Mr Andrew Petracic
Applicant
GROCON (DARLING HARBOUR) PTY LTD
Level 4, 161 Castlereagh St
Sydney New South Wales 2000
14/08/2019

The Ribbon IMAX Fit-out (SSD-8839)
Request for Additional Information

Figure 7 | Existing (left) and proposed (right) Level 3 layout (Source: Applicants EA)

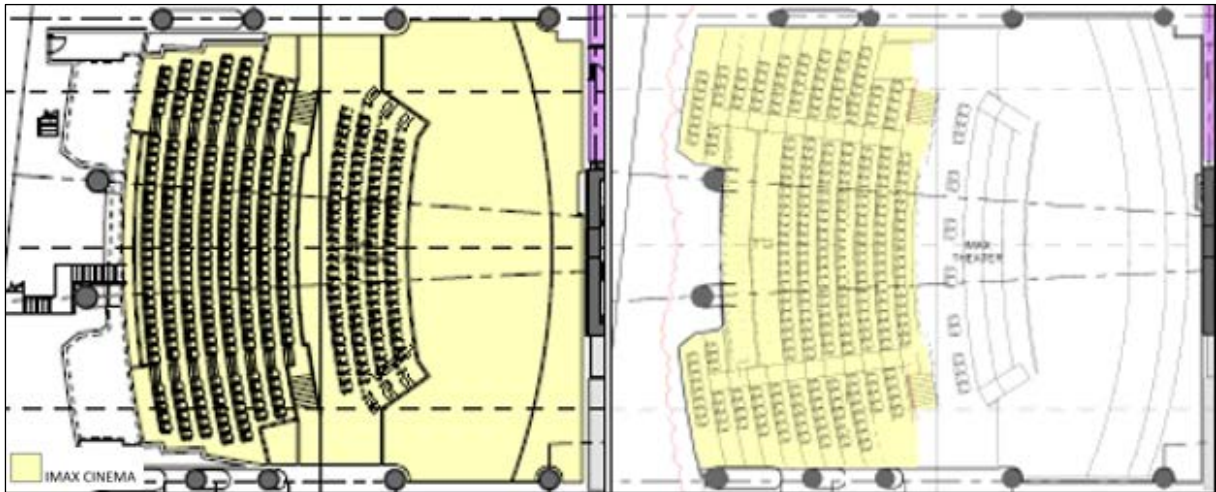
The Department notes that SSD 7388 MOD 8 approved plans for the IMAX ground floor and podium levels 1-6 showing the projection room on level 4. However, the proposed plans show the projection room on level 5 and omit levels 3 and 4 of the proposed fit out.

- provide updated fit out and architectural plans, including updated plans for levels 3 and 4, ensuring consistency with levels shown on the approved plans for SSD 7388 MOD 8
- remove the reference to 'indicative' on all plans sought to be approved.
